Our reference: ECM 9528324
Contact: Gavin Cherry
Telephone: (02) 4732 8125

19 October 2021

Response to Submissions – SSD-10479 – 200 Aldington Road Industrial Estate, Lots 54-58 DP 259135, 788-882 Mamre Road, Kemps Creek

Title
**BIO-RETENTION BASIN A
SECTIONS**

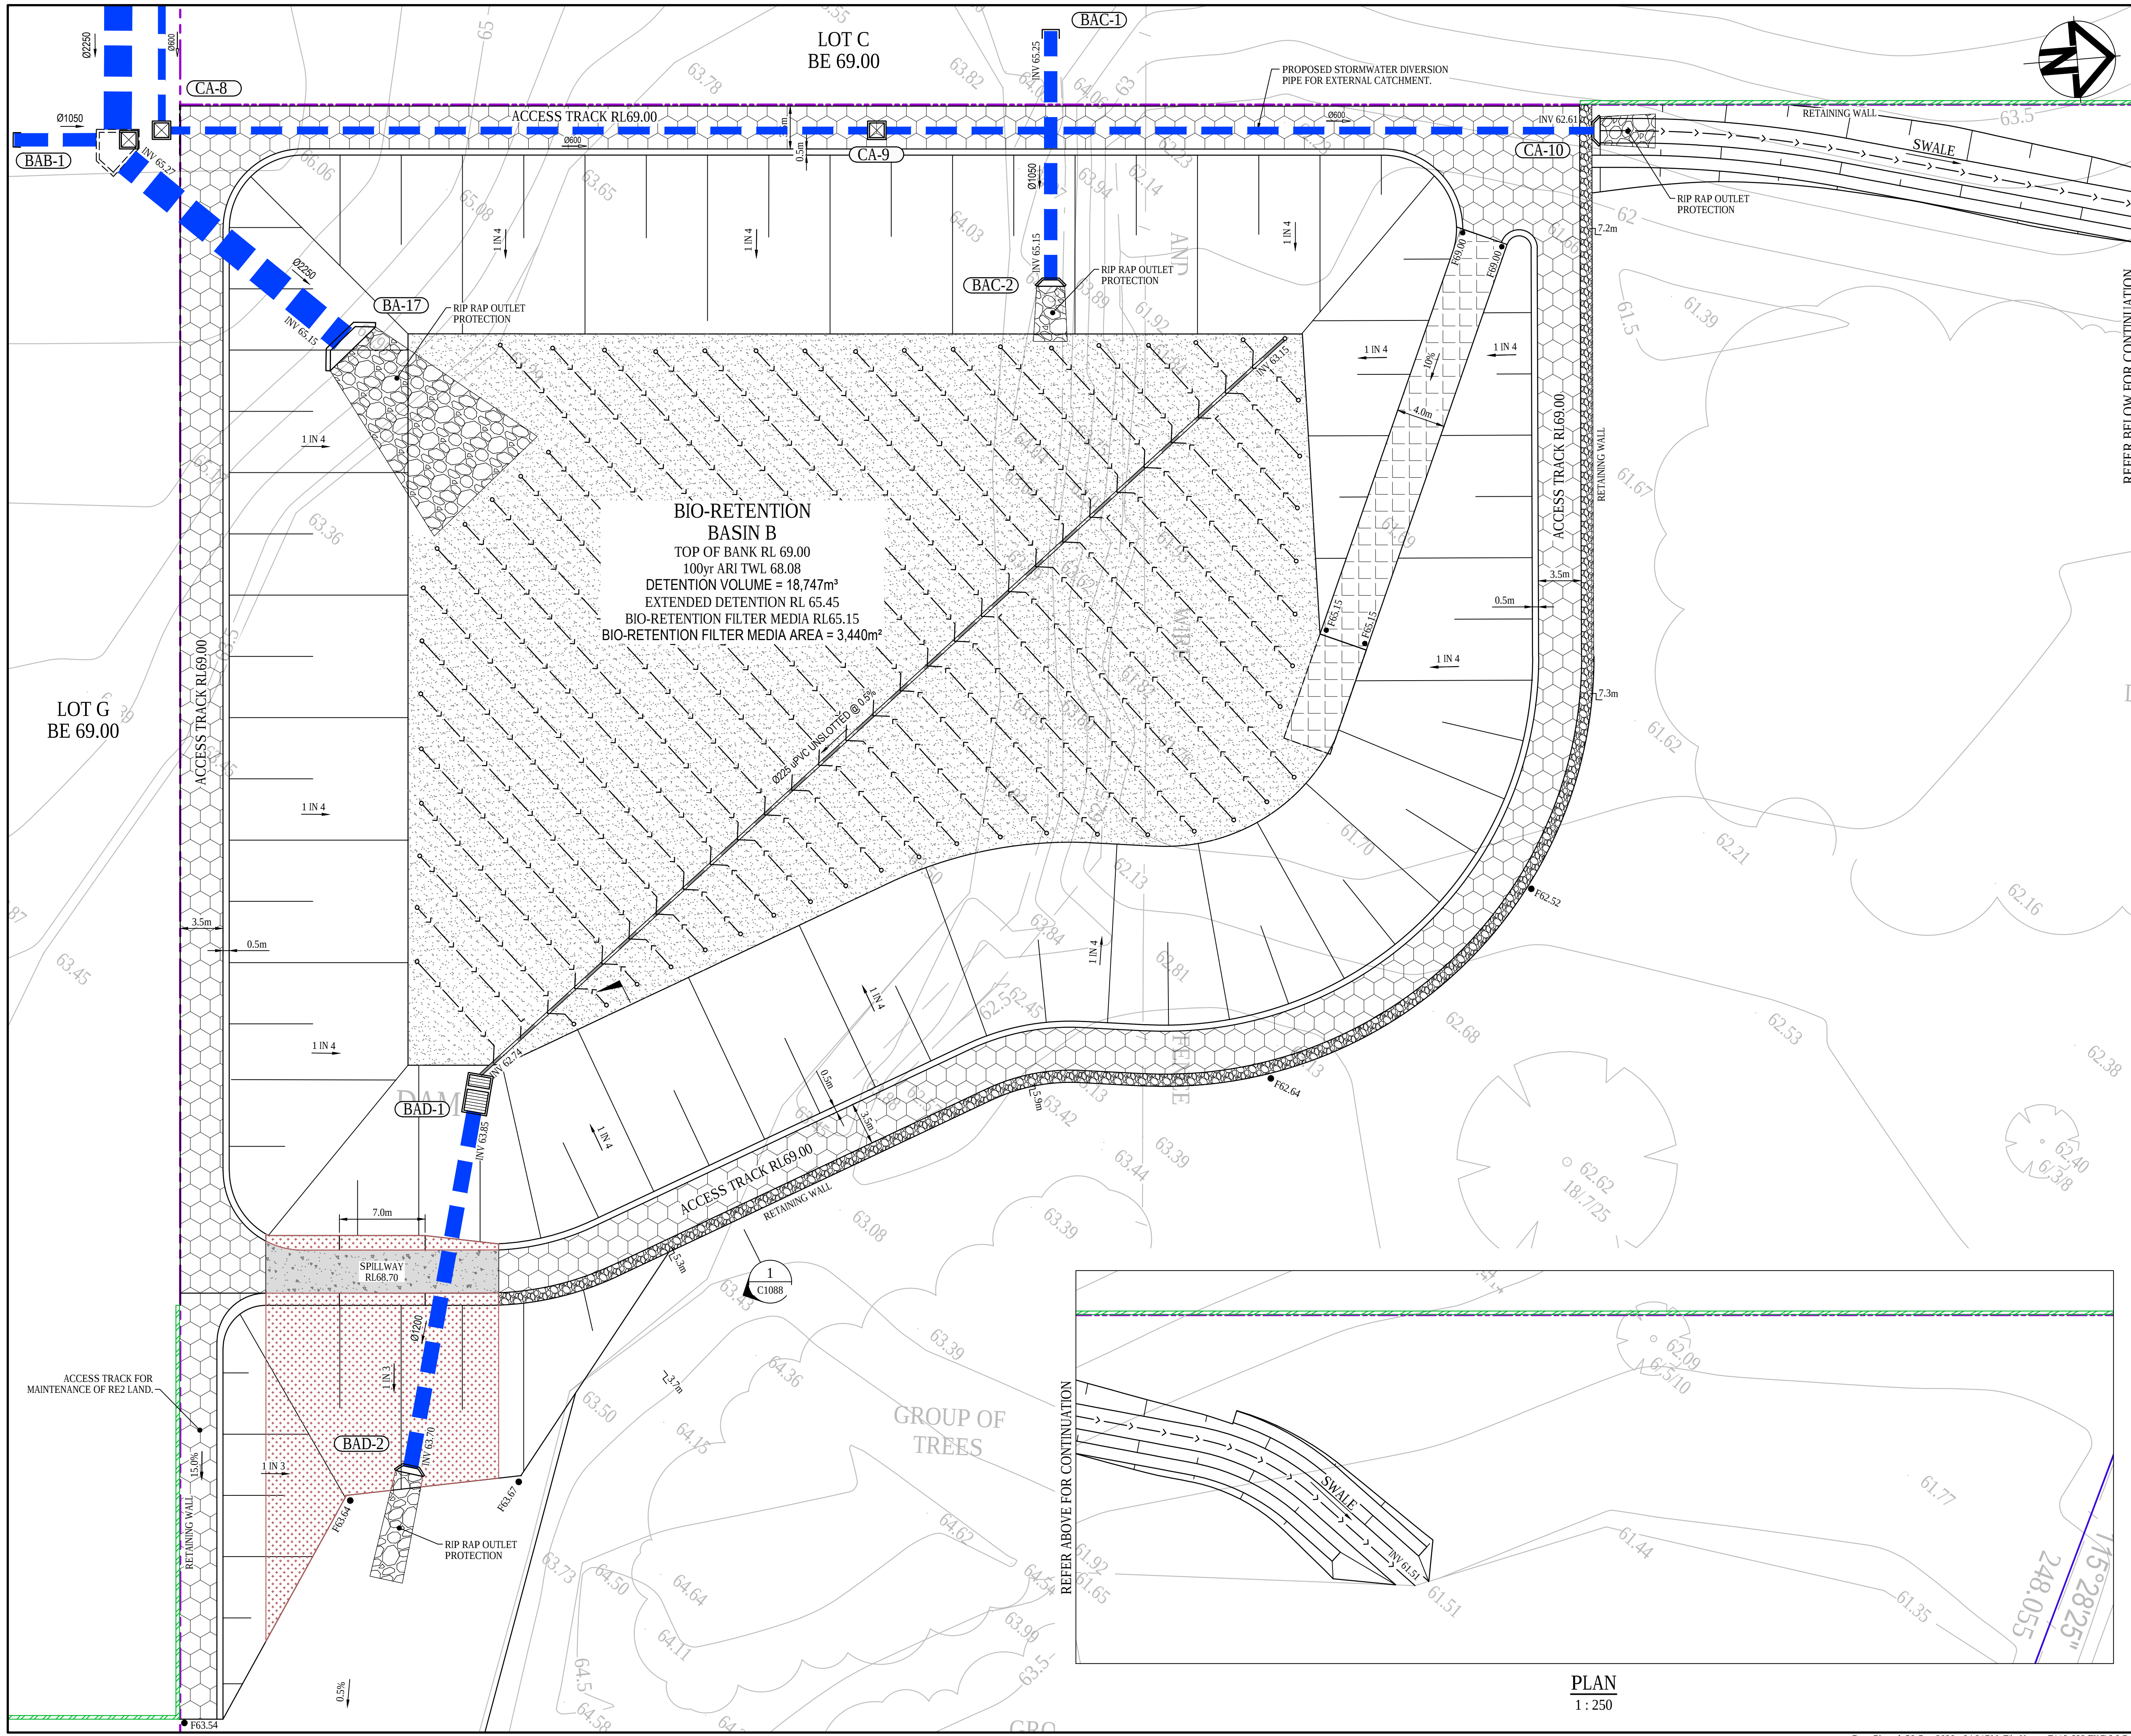
- There is currently no suggestion for on-lot OSD or stormwater treatment. As such, the proposed bioretention basins will also need to have capacity for OSD. As raised previously, Council does not support the resulting combined OSD / WSUD functions and resulting configurations of the 2 stormwater management basins nor the outcomes established via the proposed master plan. This includes the proposed depth which will not accommodate suitable planting to meet WSUD requirements.

- The proponent is again requested to reconsider the design and configuration of the stormwater management basins. This should include but not be limited to, the inlet design and flow configuration, depth of maximum ponding, sizing of basin, provision for access for maintenance, and vegetation densities and species. In this regard, there are many technical design guidelines (including those referenced in the Draft DPIE Music Modelling Toolkit which was referenced), available to assist in any revised design, including on Council's website which includes specifications for the design of bioretention systems.

Drawing Title **Landscape Concept Master Plan**

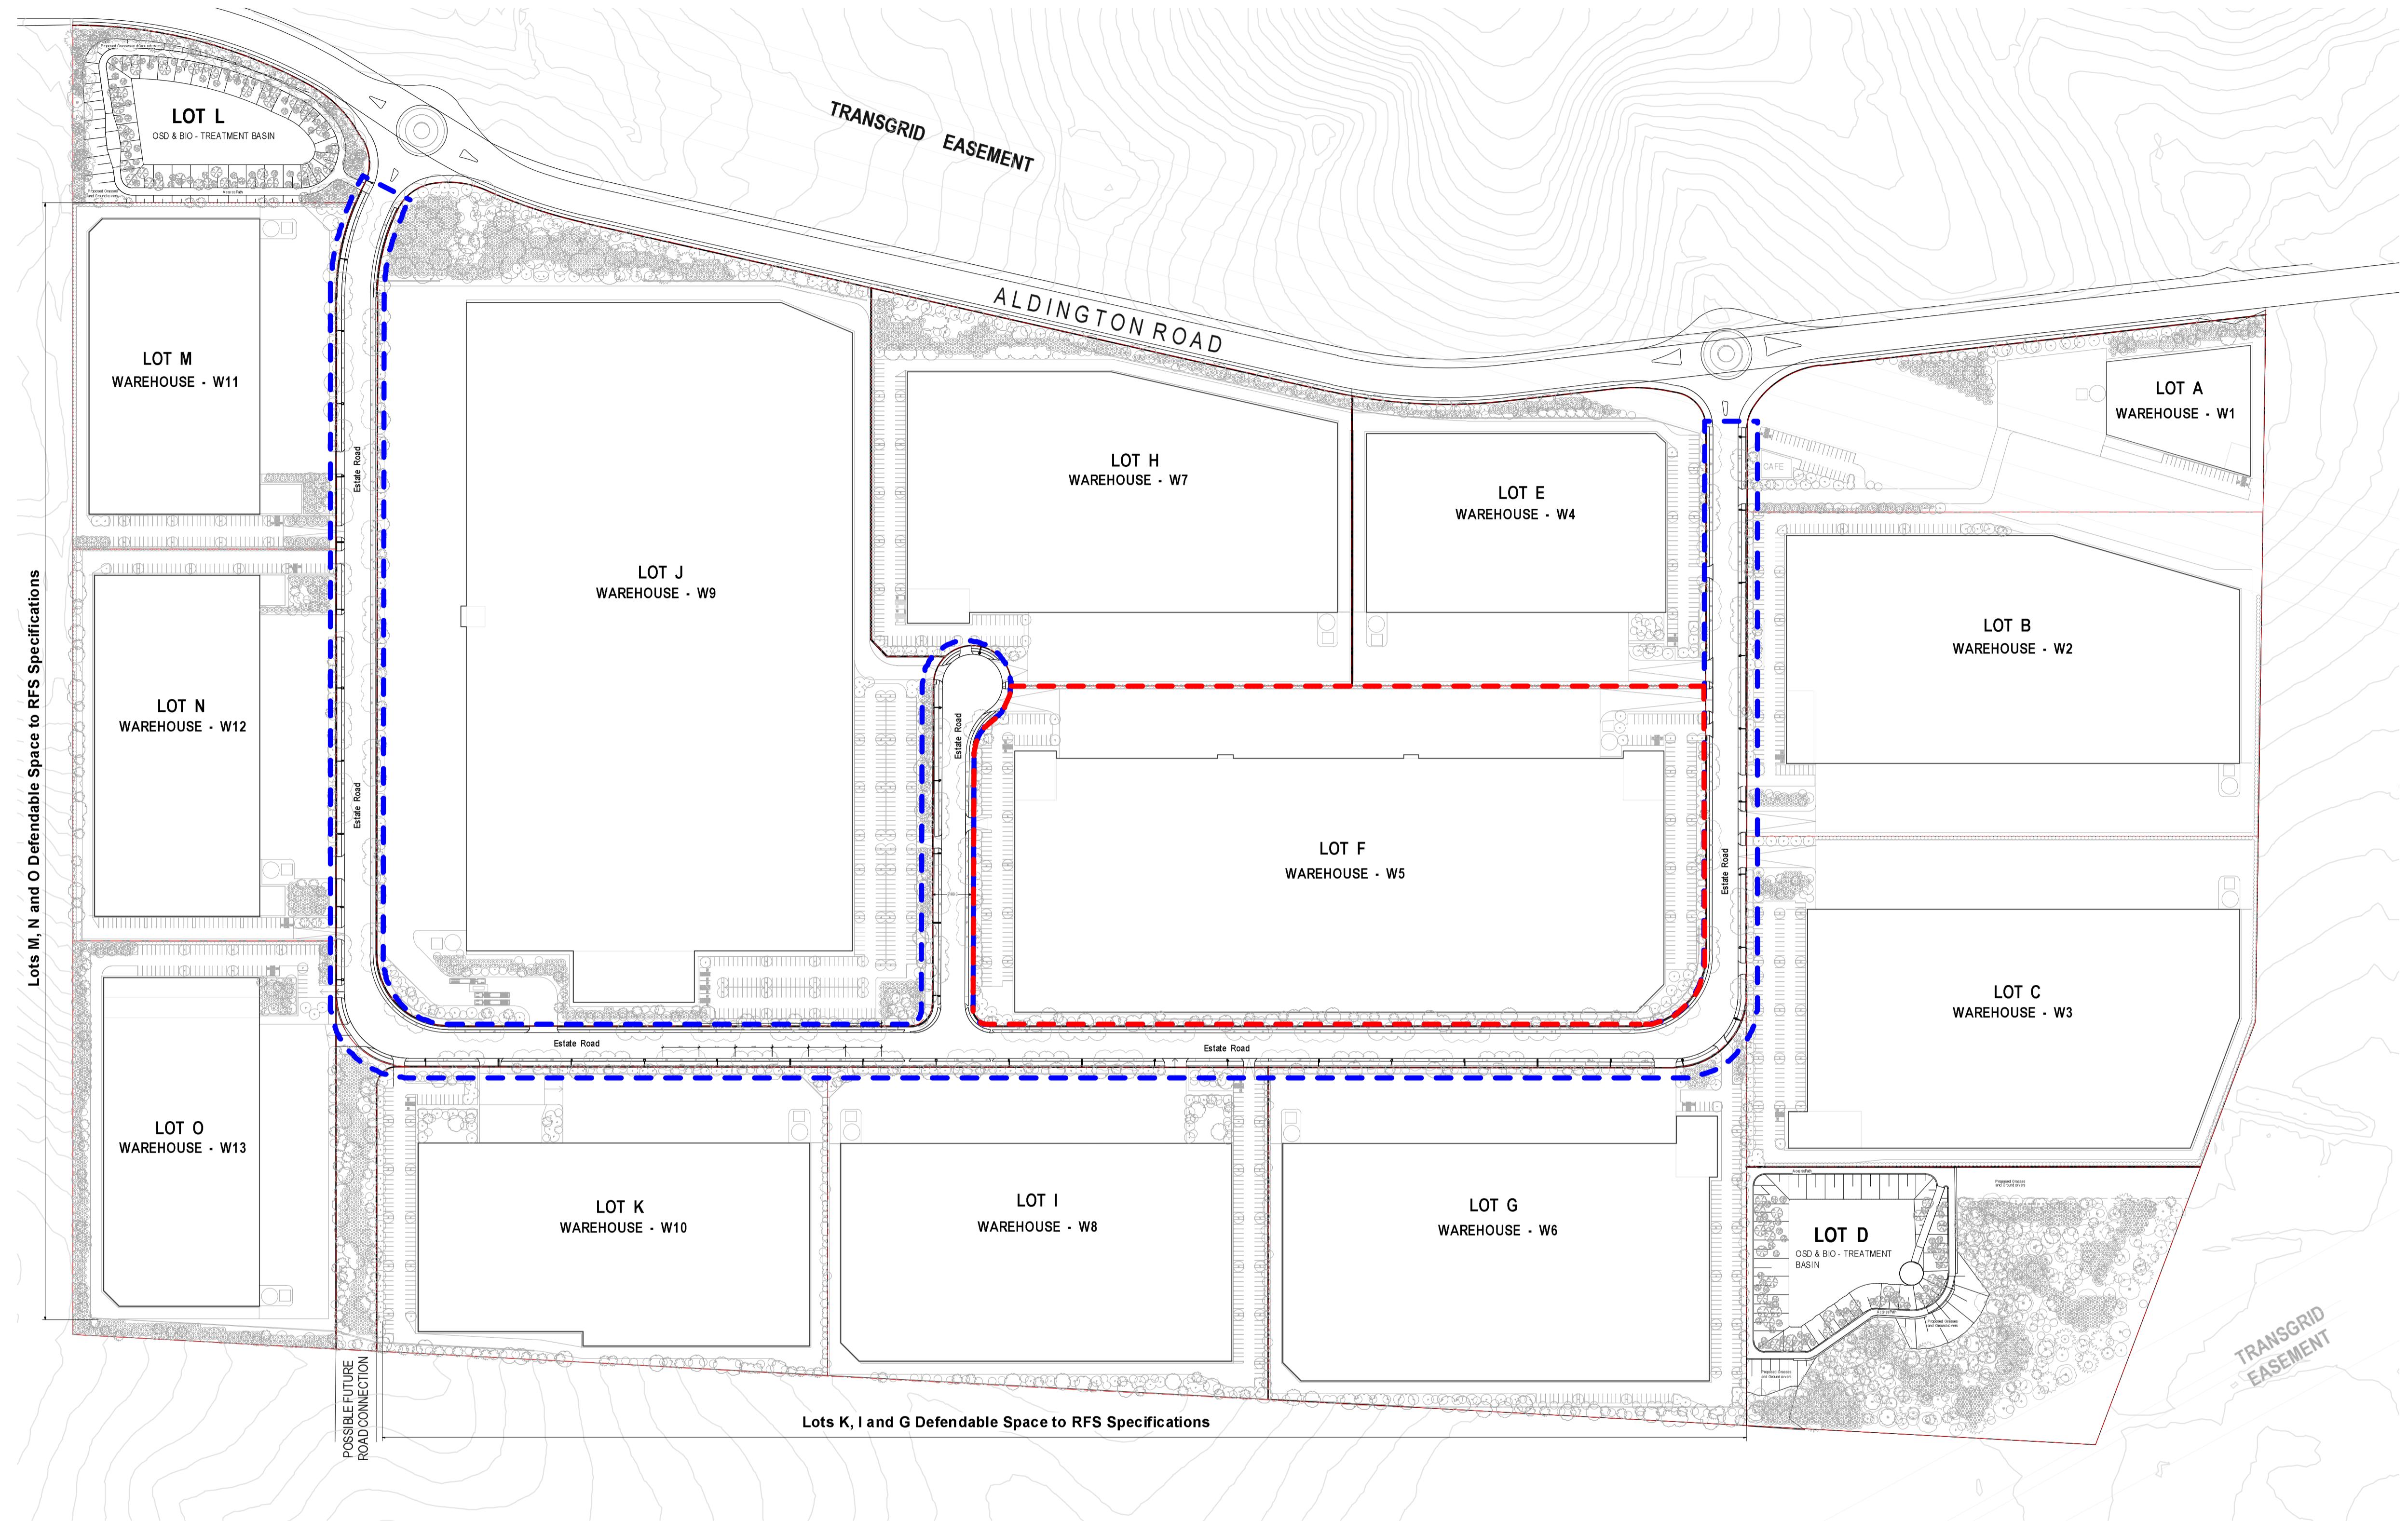
- Council previously raised a considerable number of landscape design matters that were deemed critical to inform the spatial arrangement of the proposed concept plan and subdivision layout, not to mention car parking design and building footprint locations. The amended and additional information includes additional concept landscape plans with indicative planting schedules only for each proposed allotment. The only plans with detailed planting densities relate to works proposed within the future road reserve.

- The suggested planting in the future / proposed road reserve is not supported as this is a maintenance burden on Council as the intended public road authority. The landscaping suggested in the verge is to be limited to street trees with supplementary canopy tree plantings and understorey plantings on each lot in all building and car park setback zones.

- At present only indicative planting schedules and cross-sectional details are provided within each lot contrary to what has been requested in all previous submissions made on this matter. The opportunities for landscaping in front setback zones, especially at intersection corners is however generally supported (such as Warehouse F & J) however this positive design and streetscape response isn't reflected on Lots C and G (but is reflected on Lot K at the northern western corner). Opportunities to replicate the landscape setback design response from Lots F, J & K on Lot C & G, to increase the intersection landscape setback, should be required to ensure a consistent landscape treatment at each corner of the intersection.
